July 5, 2018

PROJECT: 44395.1.1 (U-5824) Forsyth County
Widen NC 66 (Old Hollow Rd) in Walkertown from Harley Dr. to US 158

SUBJECT: Final Design Field Inspection

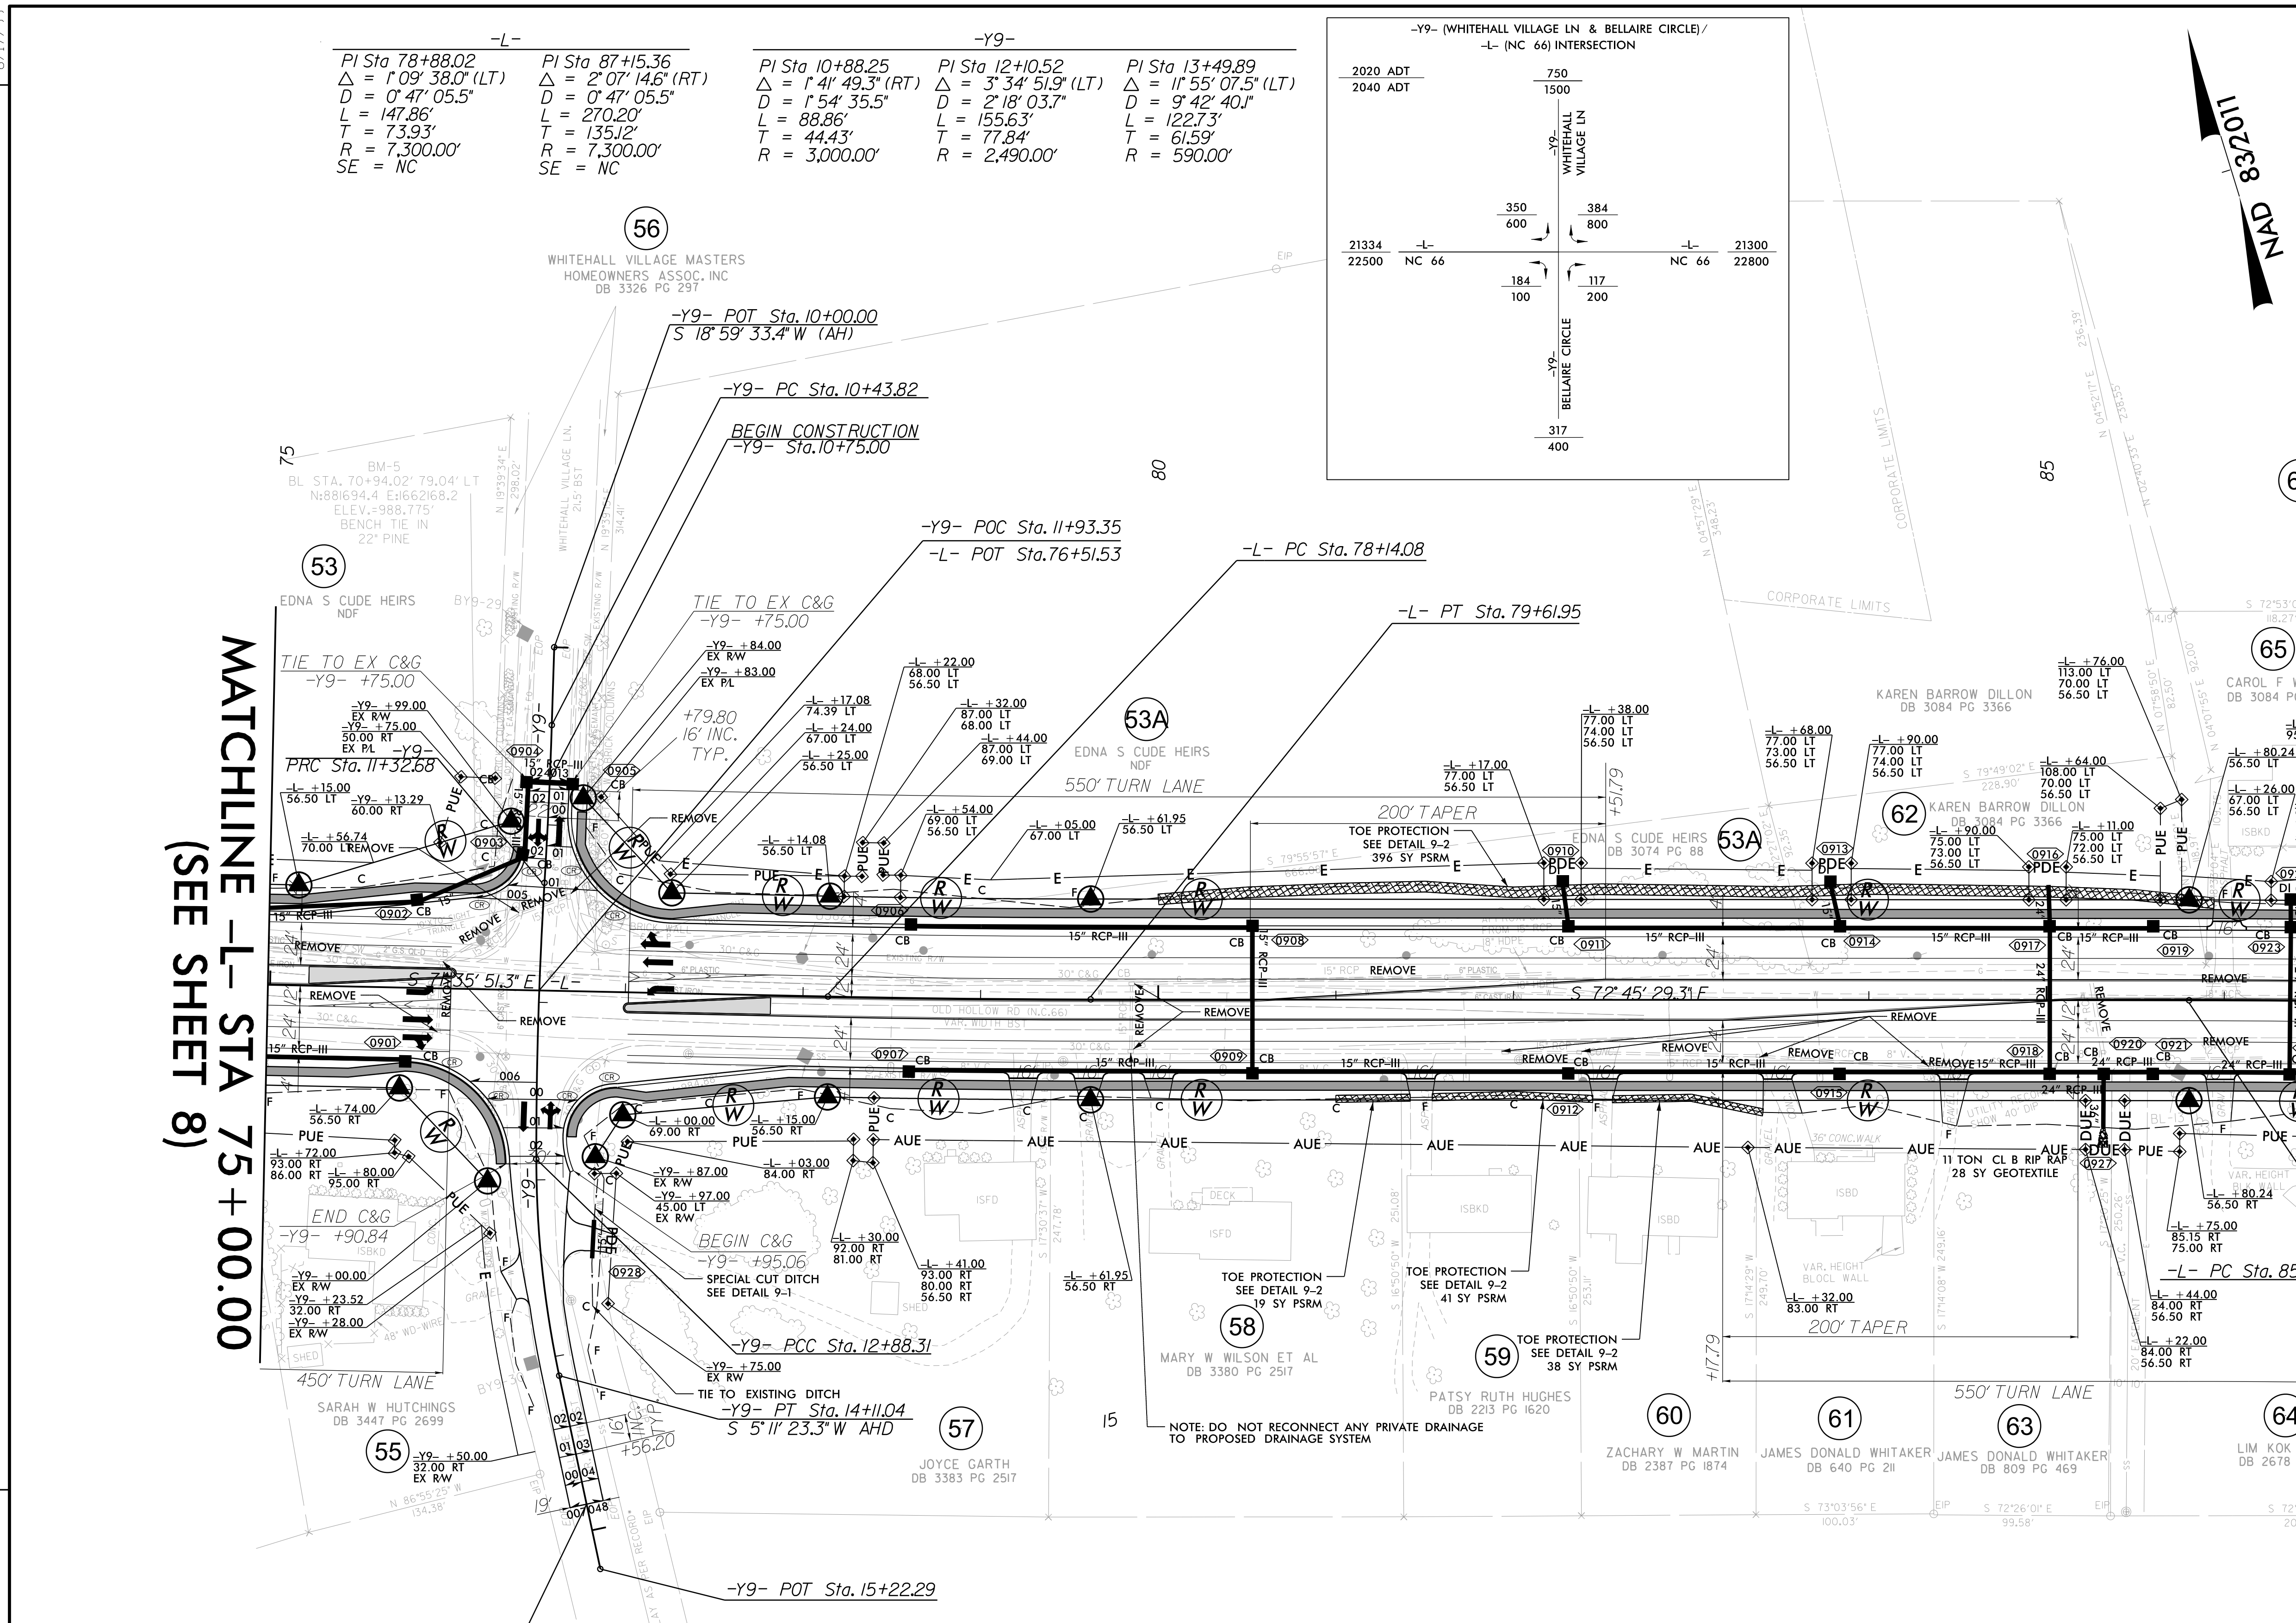
- Parcel 53 add TCE
- Parcel 56 has a basement drain that drains toward roadway... **needs to be discussed during ROW negotiations**
- Review drainage to determine if cross line pipes can be reduced (all plan sheets)
- Add turn lane length

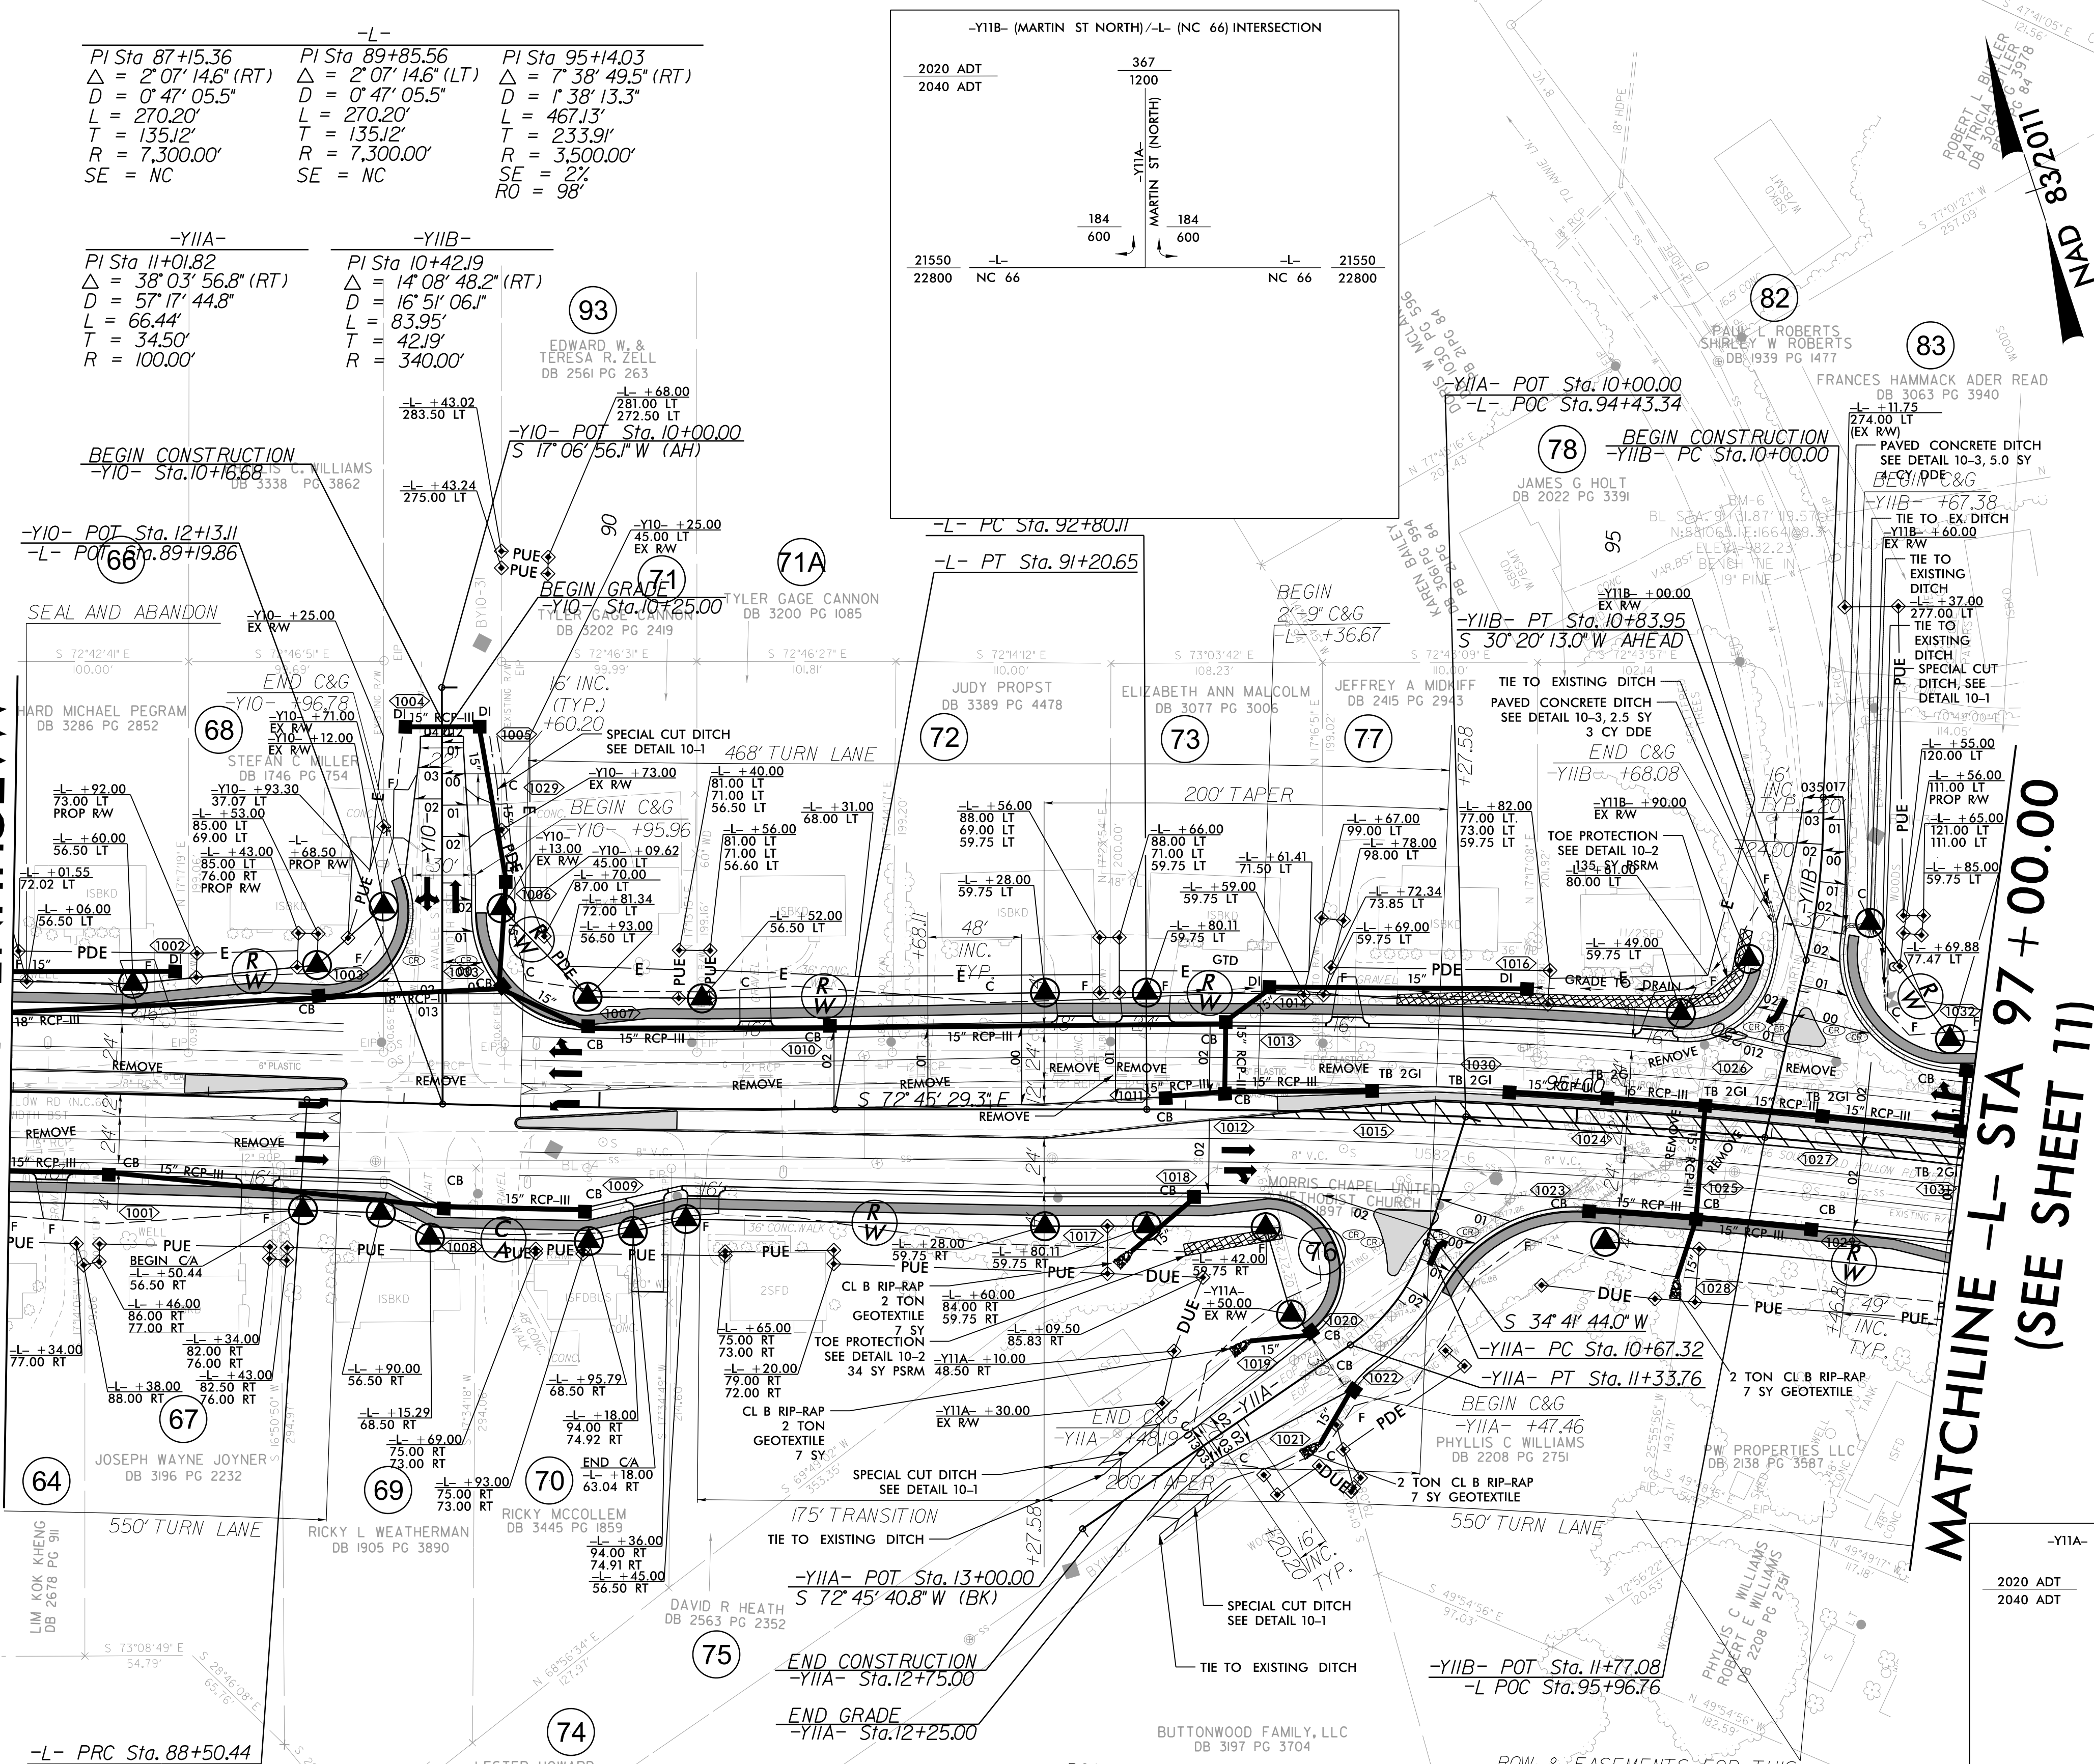
- Parcel 66, 68 Add TCE to allow slope construction and pipe installation
- Parcel 68 show driveway improvements
- Revise drainage 1009 to 1002 remove extend 1001 to 1008
- Parcel 35 extend C/A to property line
- Parcel 74 review driveway location and C/G extension

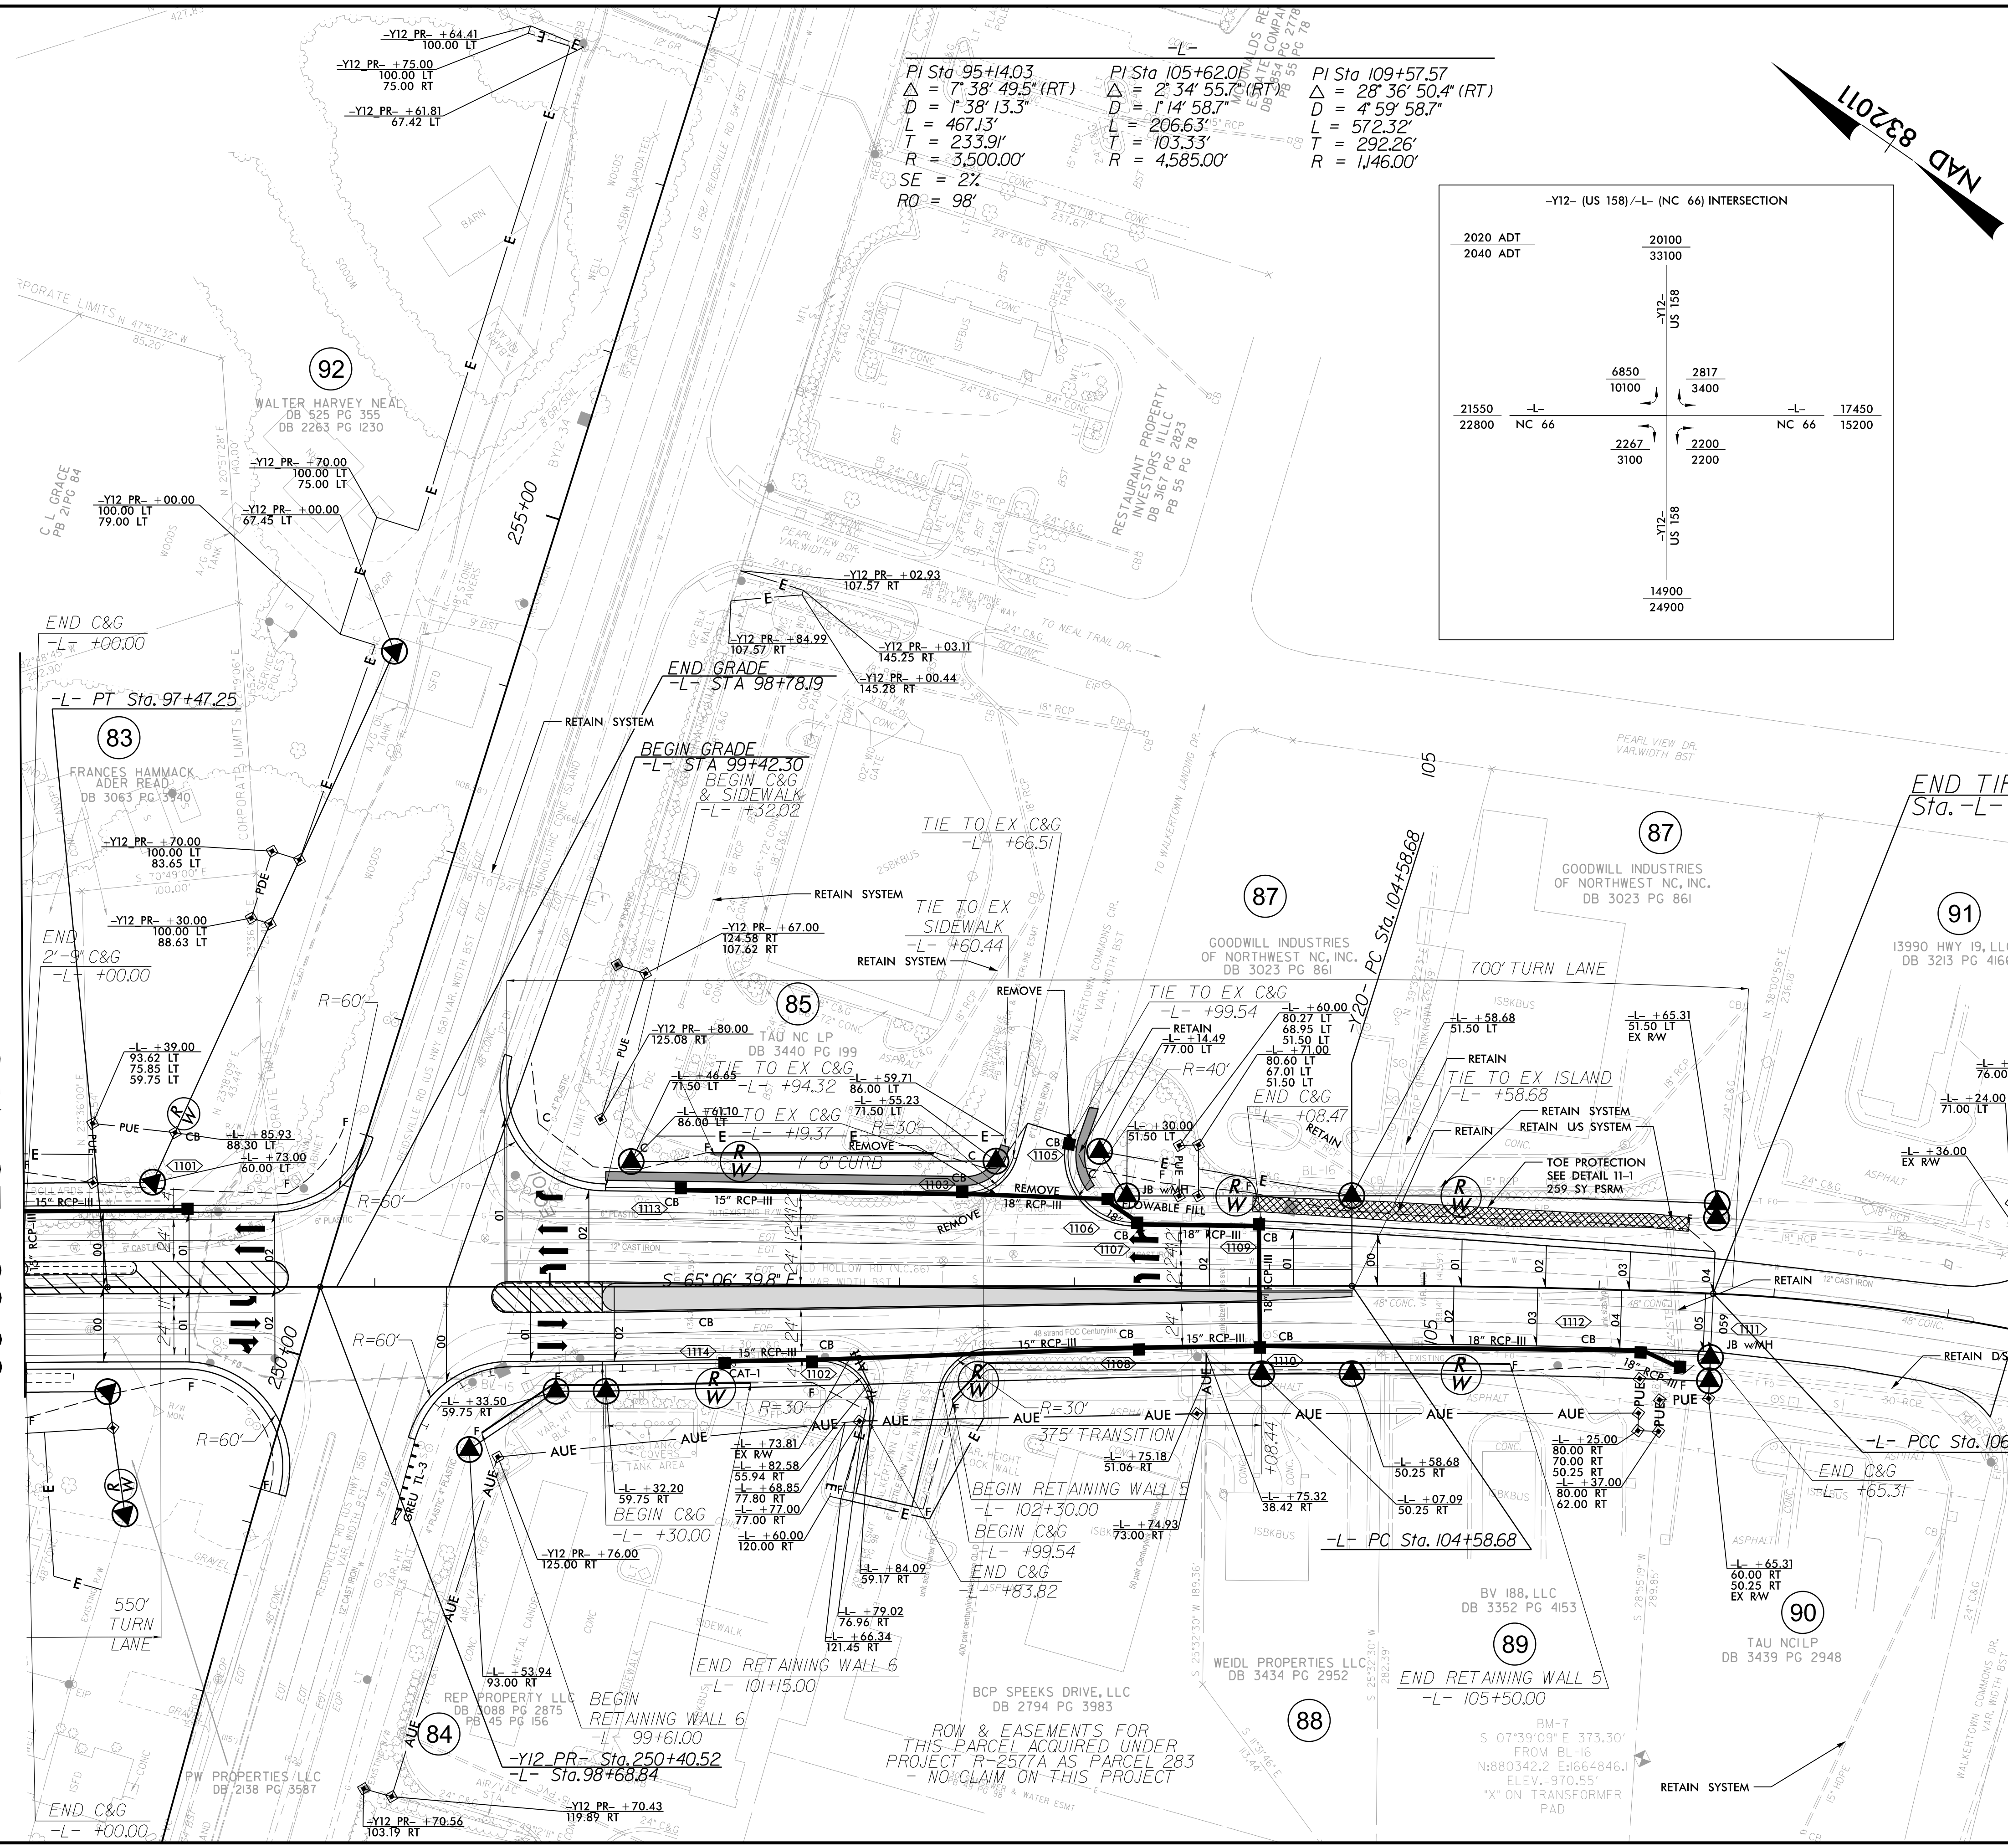
- Extend Island
- Concrete island to existing station 104+/-
- Show future improvements to US-158
